<b>Application Ref:</b>	3/2025/0408				<b>Ribble Valley Borough Council</b>  <small>www.ribblevalley.gov.uk</small>
<b>Date Inspected:</b>	N/A	<b>Site Notice:</b>	N/A		
<b>Officer:</b>	EP				
<b>DELEGATED ITEM FILE REPORT:</b>					<b>REFUSED</b>

<b>Development Description:</b>	Certificate of Lawfulness for a proposed single storey rear extension.
<b>Site Address/Location:</b>	<b>1 Eastfield Drive West Bradford BB7 4TQ</b>

drawing title <b>EXISTING AND PROPOSED ELEVATIONS</b>		
drawn by JL	date 03/05/25	
scale 1:50 @ A1	Drawing no. 2025/PD02	revision ----

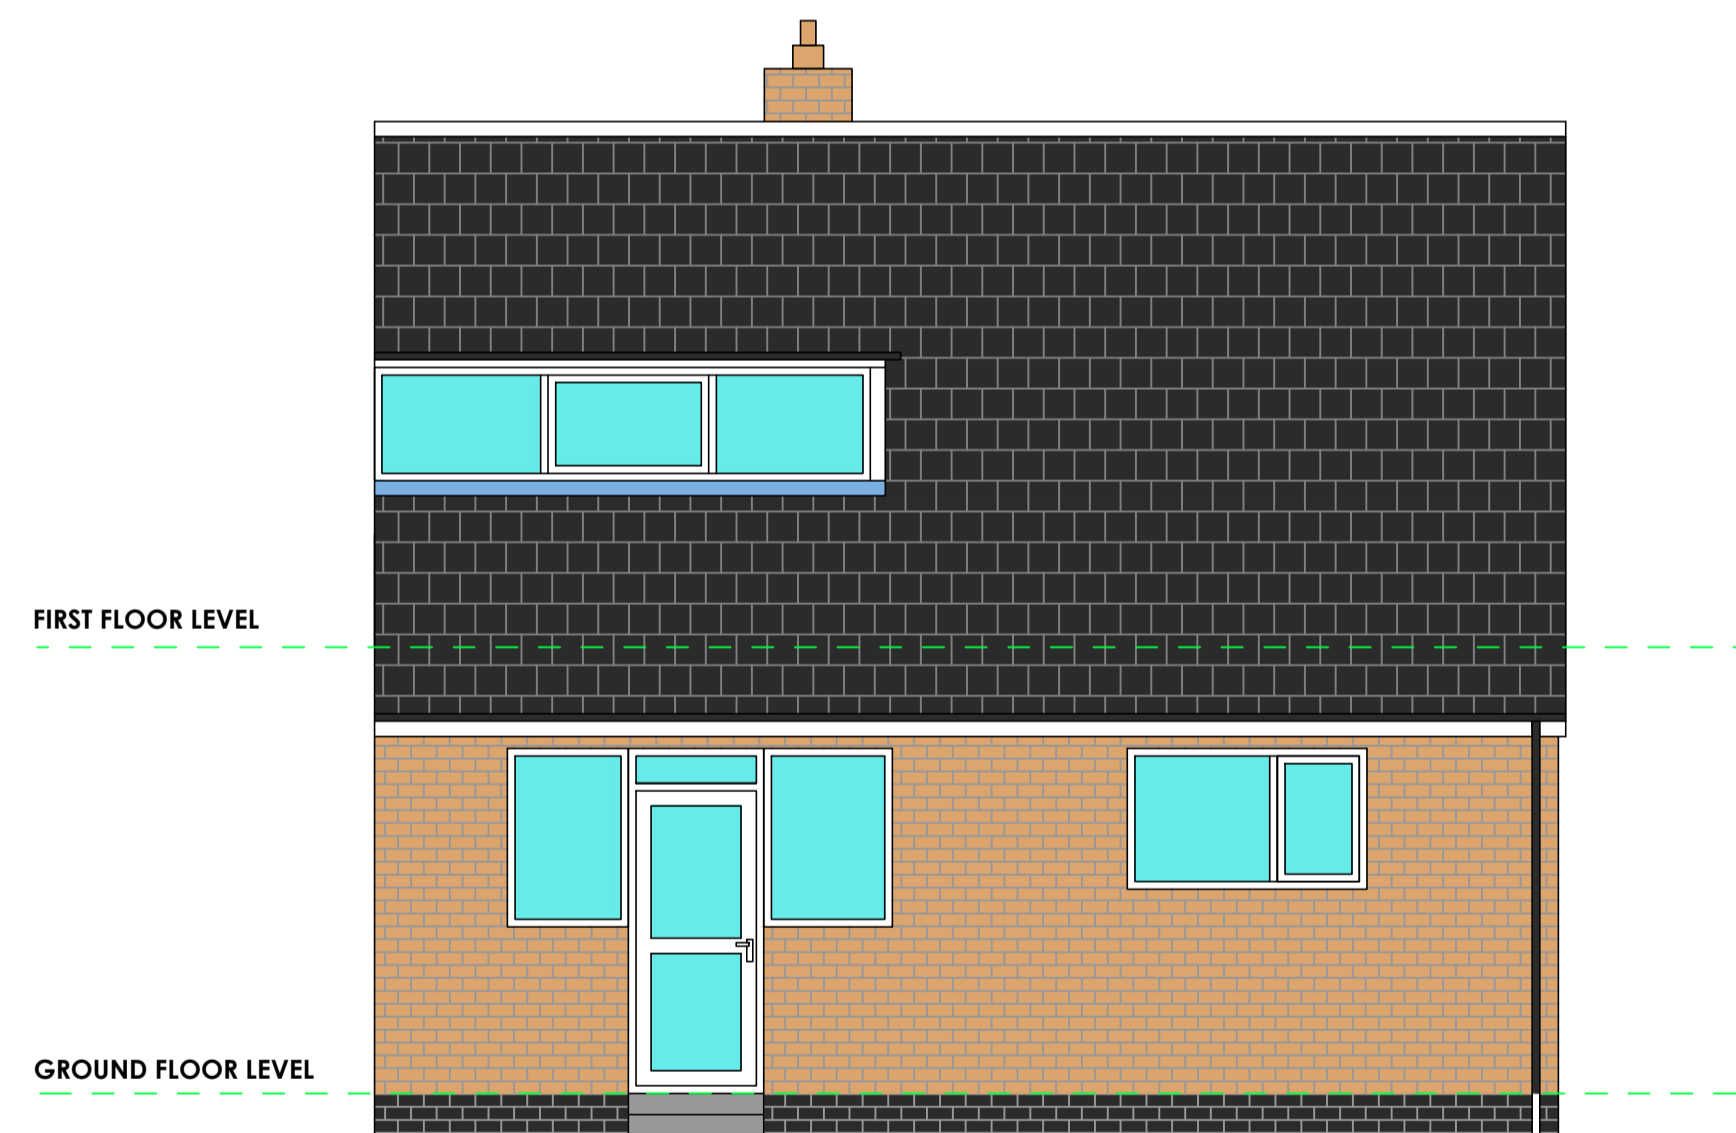
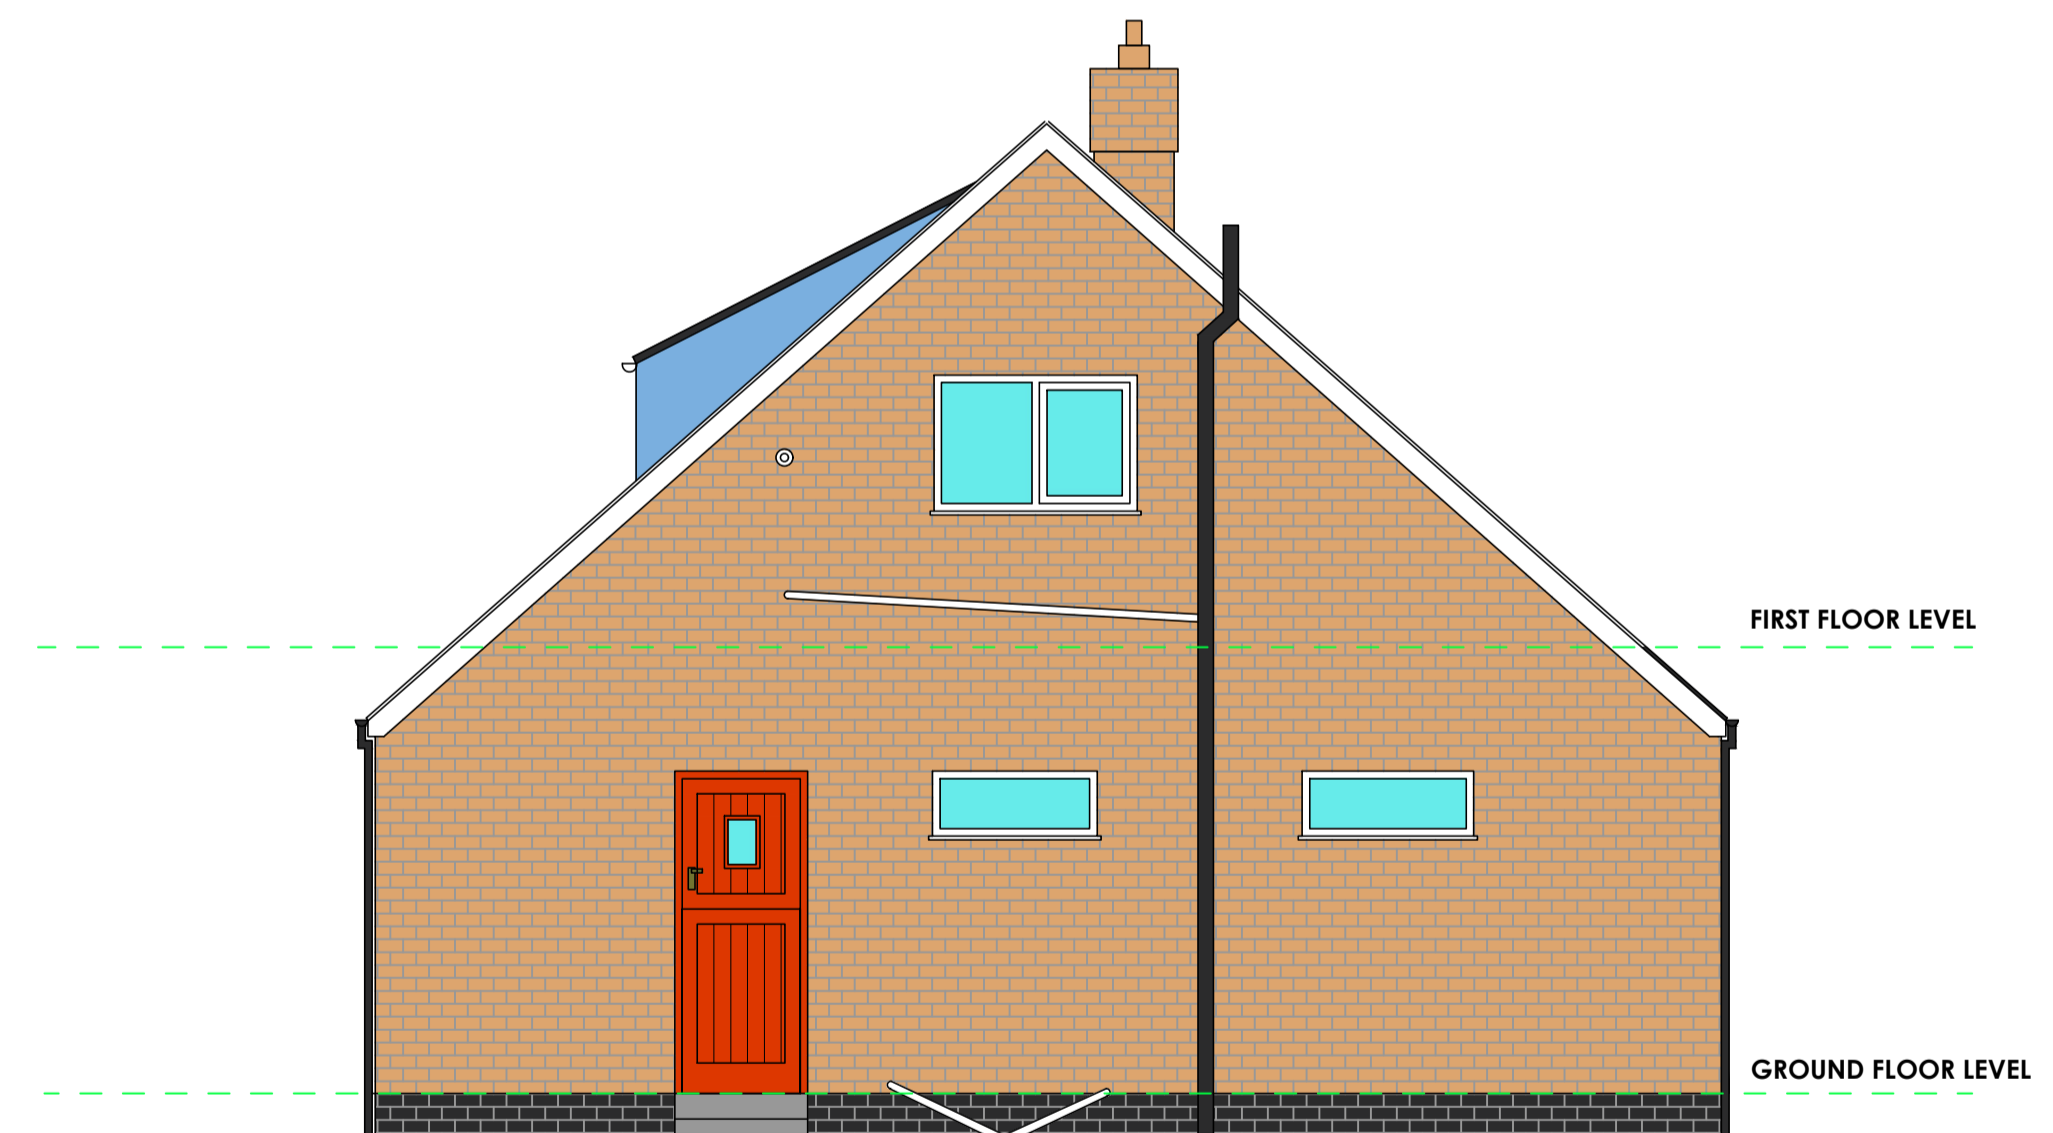
**The height of the eaves of the proposed extension would exceed the height of the eaves of the existing dwellinghouse by approximately 0.5m.**

**Under A.2(a), render is a type of cladding which, if applied to any part of the exterior, withdraws permitted development rights under Part 1 Class A for a dwelling in the AONB. The technical guidance says that this applies both to the original dwelling and to any part of it which is enlarged. As the proposed extension is to be faced in render, it fails the above criteria.**

The proposed works do not constitute permitted development under The Town and Country Planning (General Permitted Development) (England) Order 2015 Schedule 2, Part 1, Class A as the height of the eaves of the proposed extension would exceed the height of the eaves of the existing dwellinghouse by approximately 0.5m contrary to criteria A.1(d). In addition, in accordance with criteria A.2(a) the development cannot be cladded in render as proposed as the dwelling is within the designated National Landscape (formerly the AONB).
